An  
Bord  
Pleanála

## Memorandum ABP-320946-24 – Request for Further Information

**To:** Una Crosse, ADP  
**From:** Hugh O'Neill, SPI  
**Re:** 320946-24 – Request for Further Information  
**Date:** 18<sup>th</sup> November 2024

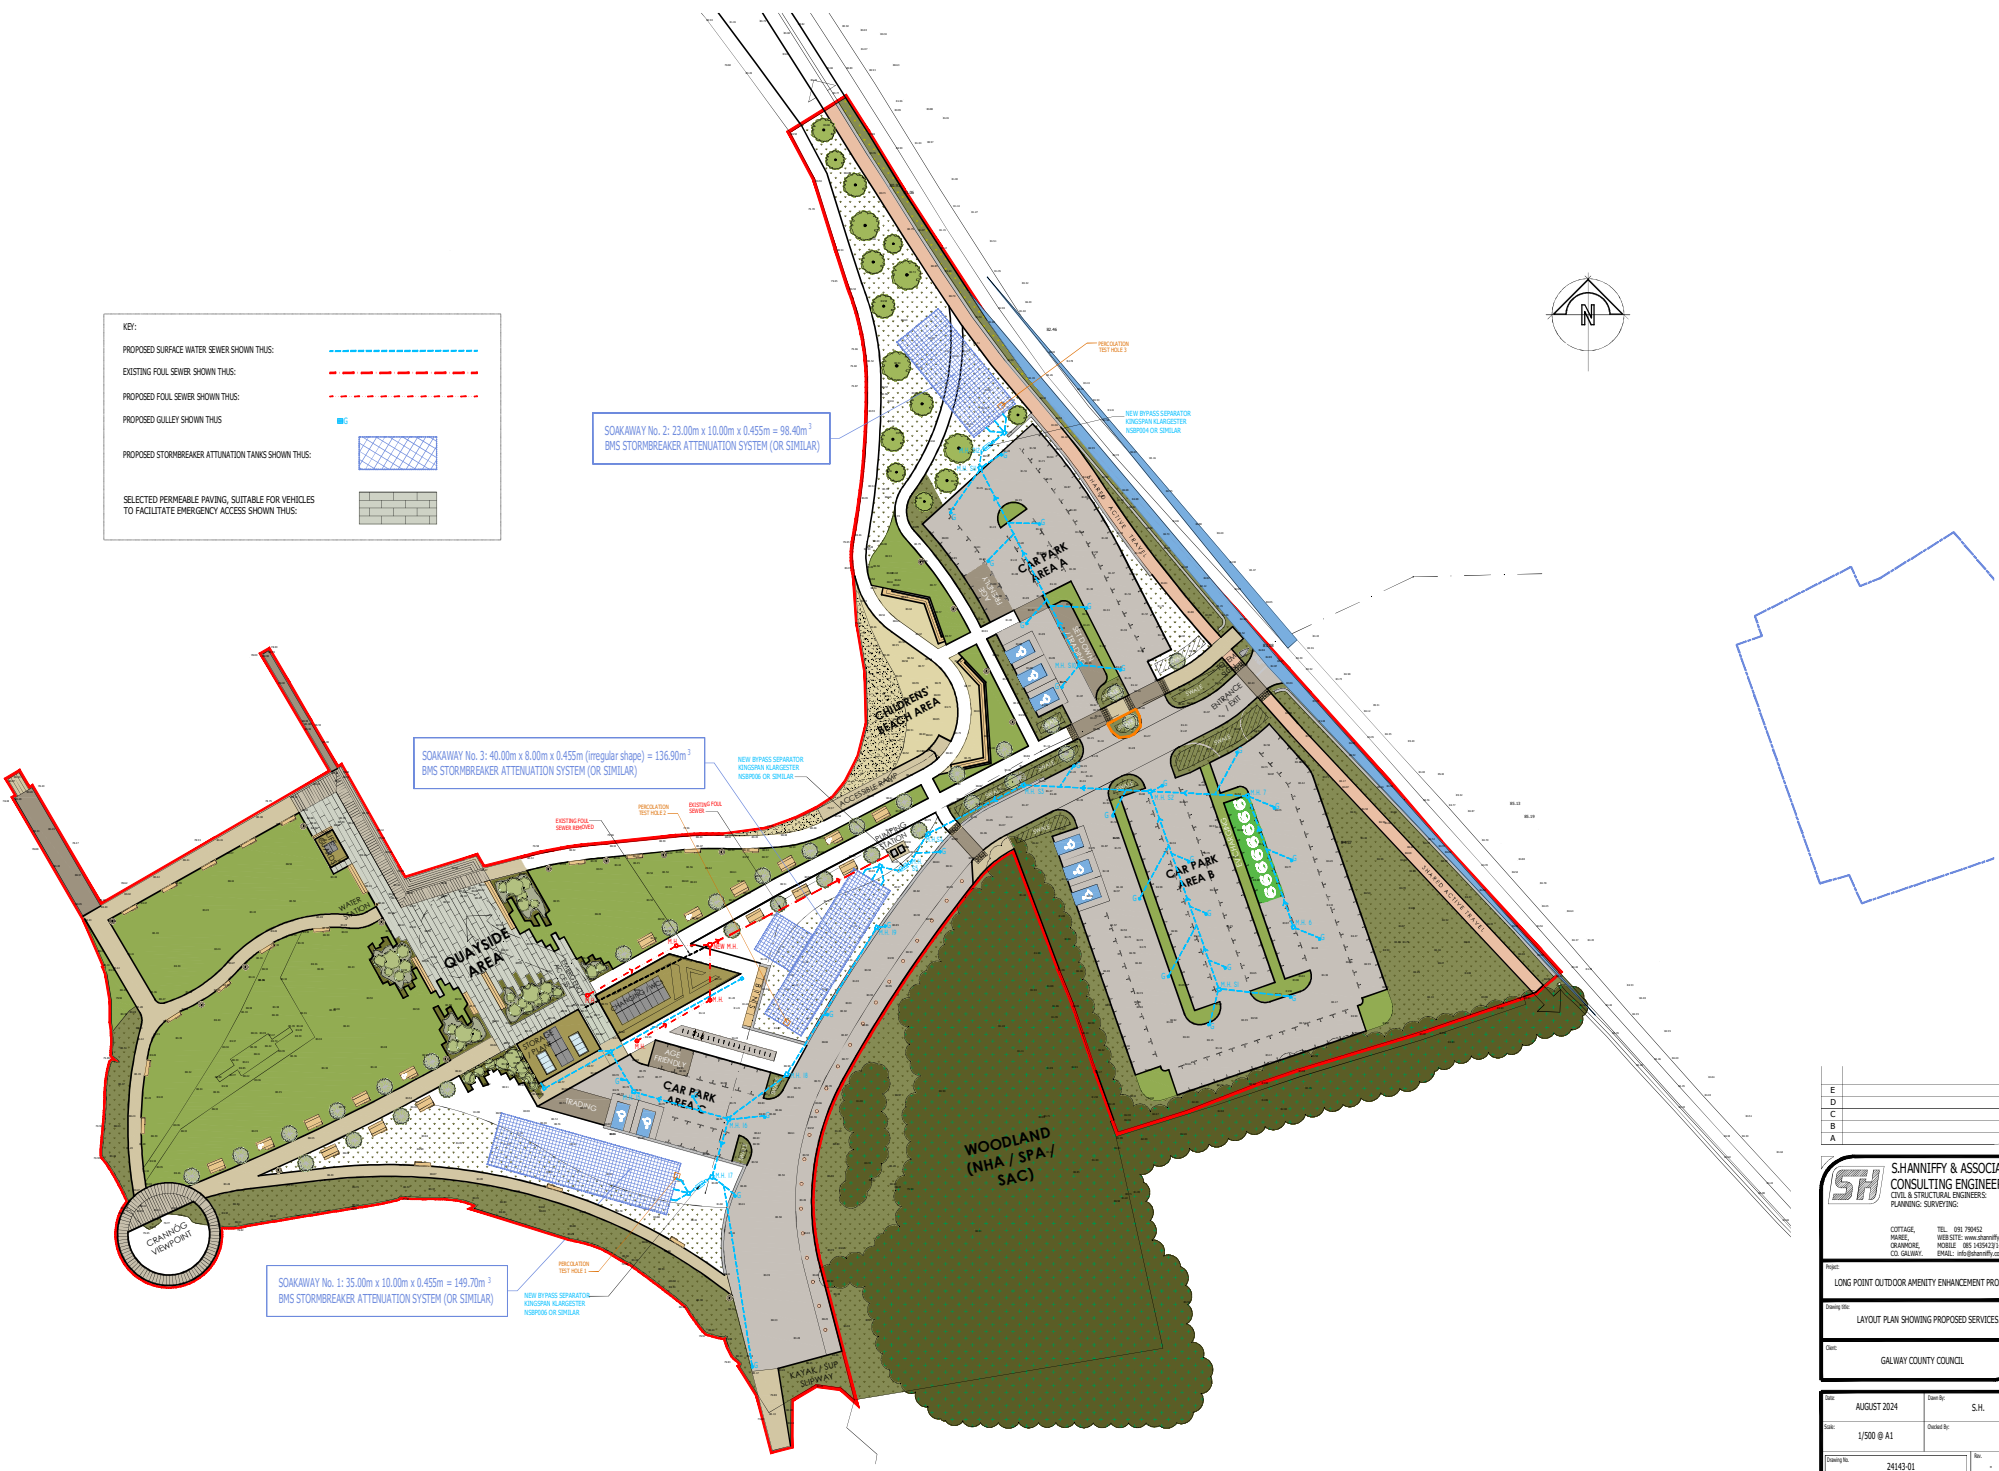
Further information is required in the form of clear drawings/sections demonstrating proposed site levels with reference to the proposed chamber levels of bypass separators and silt traps. This shall demonstrate how these structures are incorporated into the landscaping plan.
